WEST SUSSEX COUNTY COUNCIL CONSULTATION

TO:	Arun District Council FAO: Claire Potts
FROM:	WSCC - Highway Authority
DATE:	7th April 2022
LOCATION:	Barnham, Eastergate, Westergate BEW Parcel SC1 Barnham
SUBJECT:	BN/11/22/OUT Outline application with all matters reserved (except for the A29 Realignment) for the demolition of existing structures and mixed use development to provide residential dwellings (Use Class C3), Care Home/Senior Living Accommodation (Use Class E/F2/Sui Generis), a Primary School plus open space, landscaping, drainage and all other associated ancillary works; and realignment of the A29 and early connection to existing A29 including construction of a new road carriageway, junctions and associated infrastructure. This application also lies within the parish of Aldingbourne, affects the setting of listed buildings, affects the character & appearance of the Eastergate Church Lane Conservation Area and affects a Public Right of Way. This application is the subject of an Environmental Statement.

DATE OF SITE VISIT:	31 st March 2022
RECOMMENDATION:	More Information Required
S106 CONTRIBUTION TOTAL:	Amount TBC

Drawing Title
**INITIAL BRIDGE OPTIONS
MULTI SPAN**

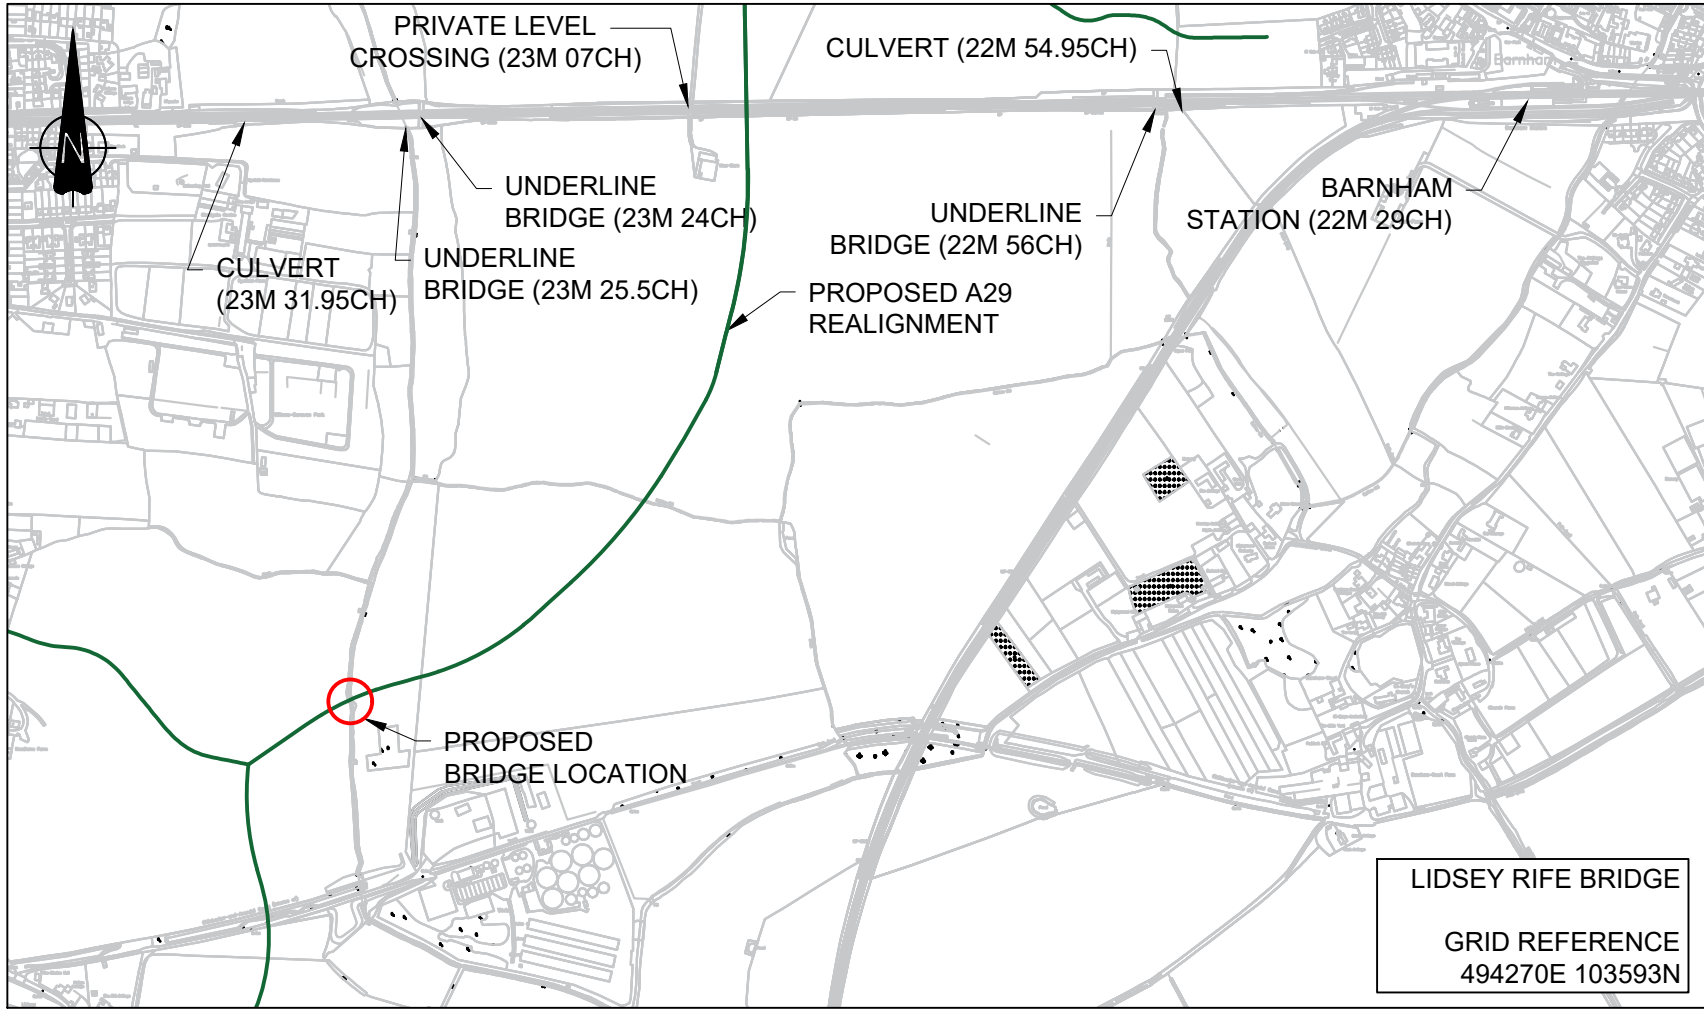
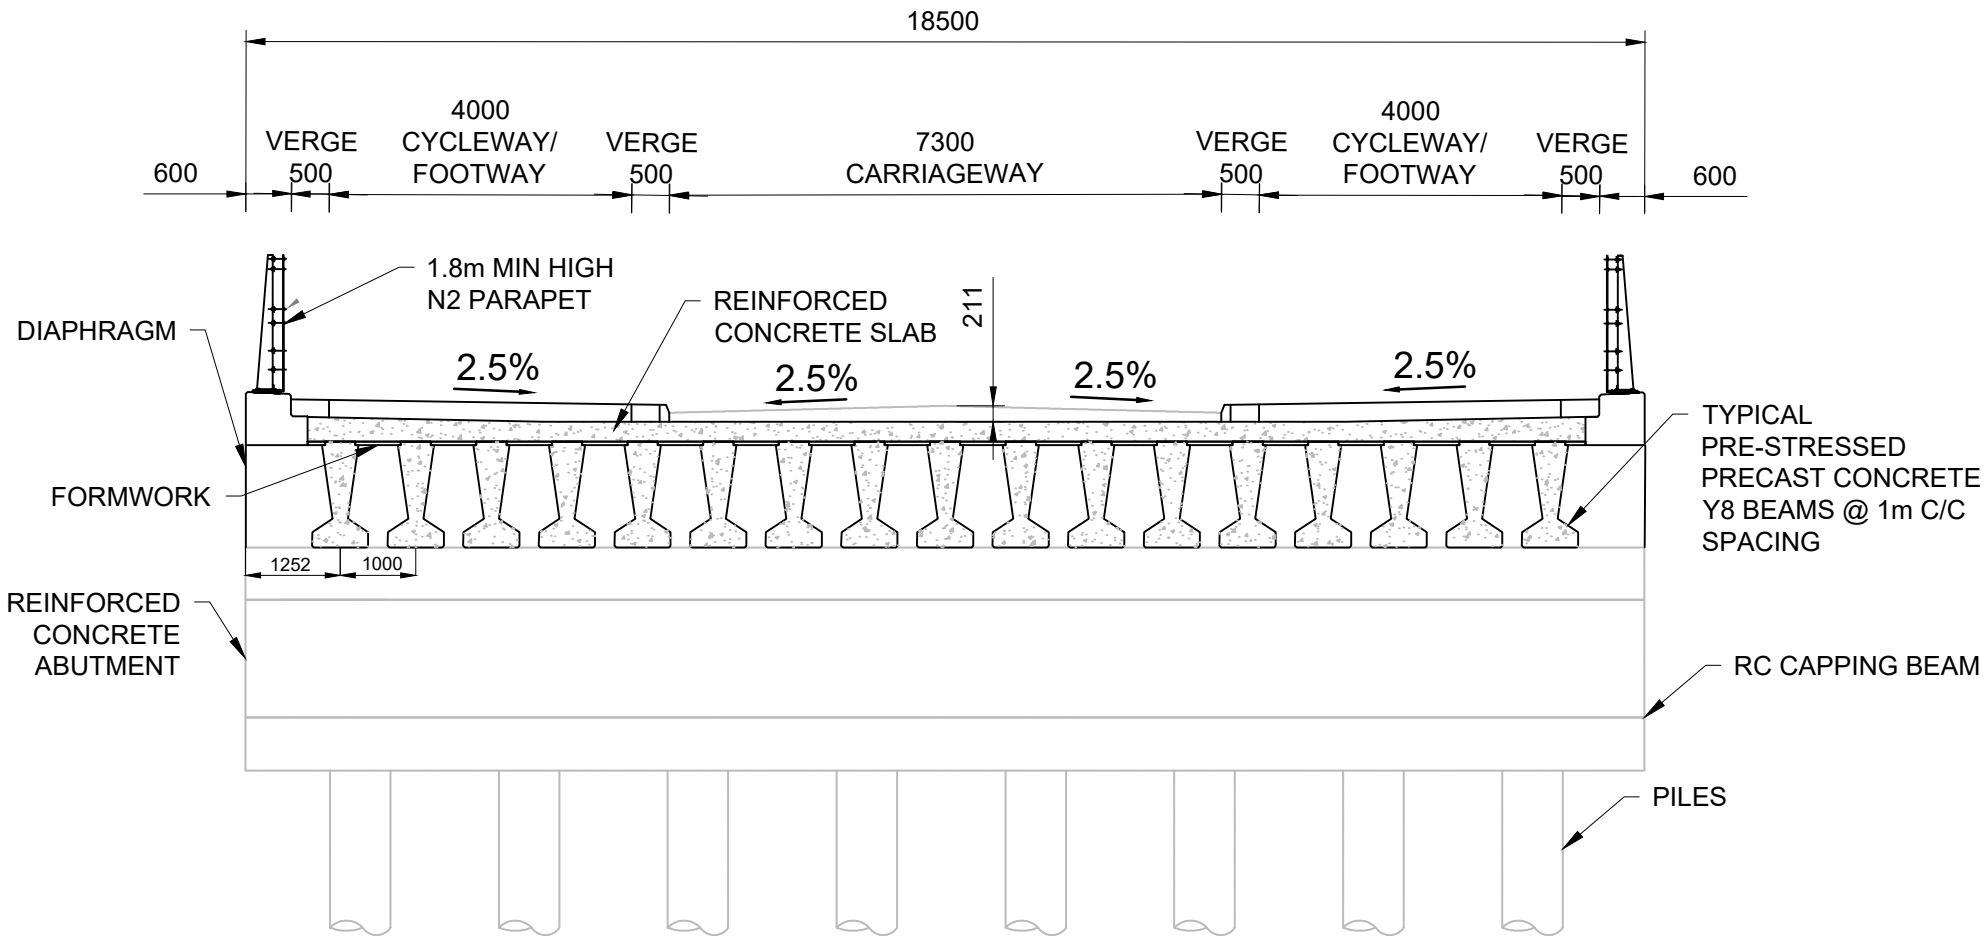
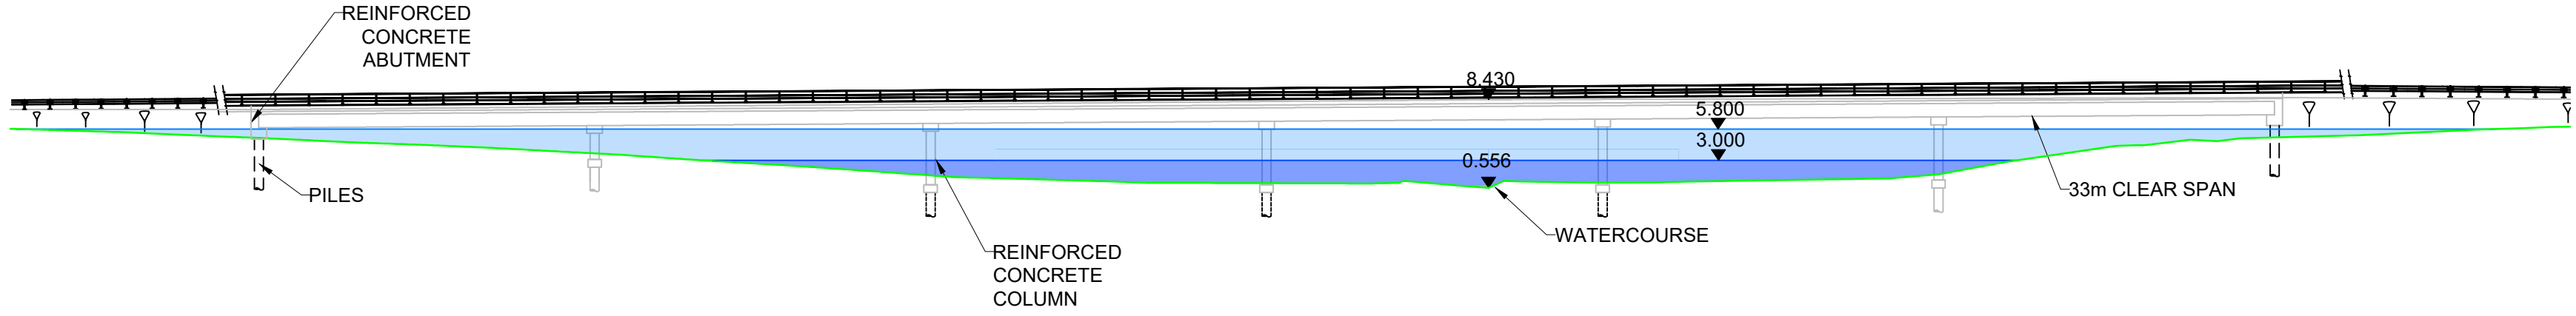
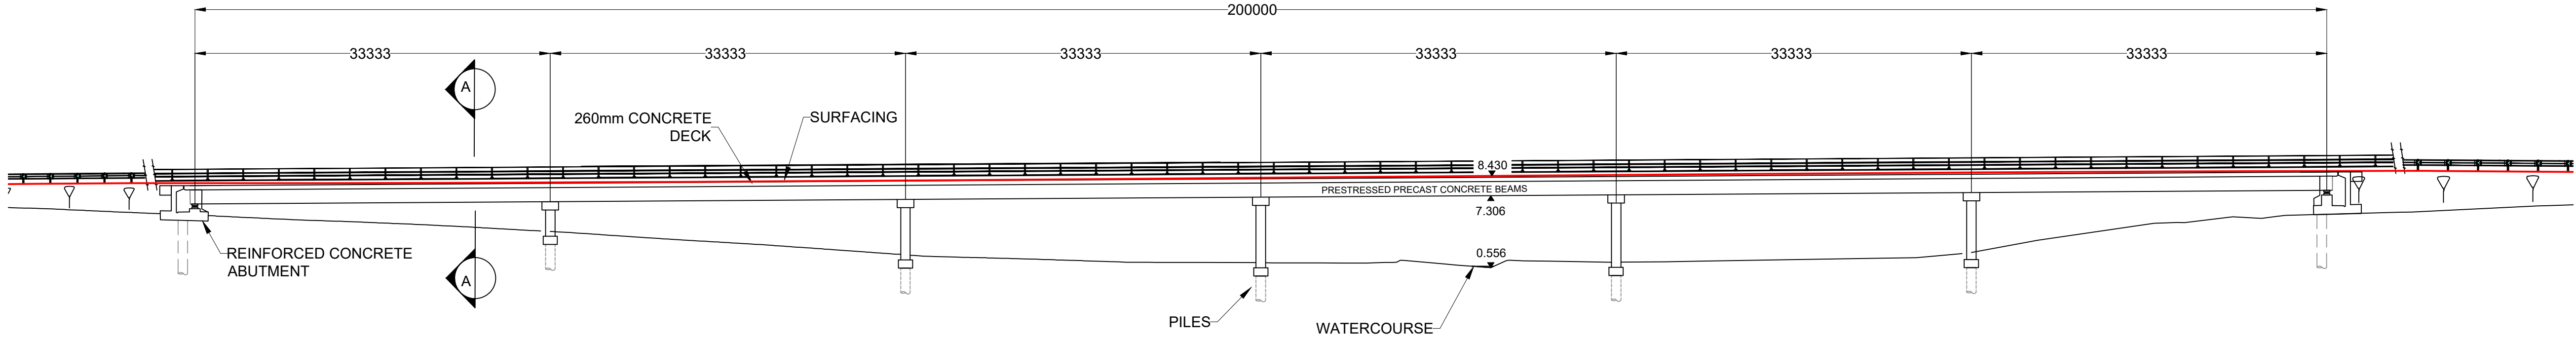
The Technical Note (TN) is geared towards either a) a 200m long multi-span viaduct, or b) a 30m single span structure. The reason for the massive variance is as stated in the front of the report, see screen grab below.

However, recent discussions with the Environment Agency have reduced to the flood level to 2.2m AOD at point of crossing. As a result, the structure clearance can be reduced and therefore the multi span bridge is no longer a viable option. For information purposes, the multi span structure proposal is included within the report.

Given as much, the vast majority of the content of the TN is of limited use as it only discusses 1No. viable option. The TN should have addressed various single span options (e.g. weathering steel, U or W beams similar to the Options Report for the rail bridge). As a result, the drawing is certainly of interest but also of limited value (in the context of 'options'). Perhaps the rife bridge could basically be a repeat of the rail bridge (the widths should be identical and the spans are very similar)?
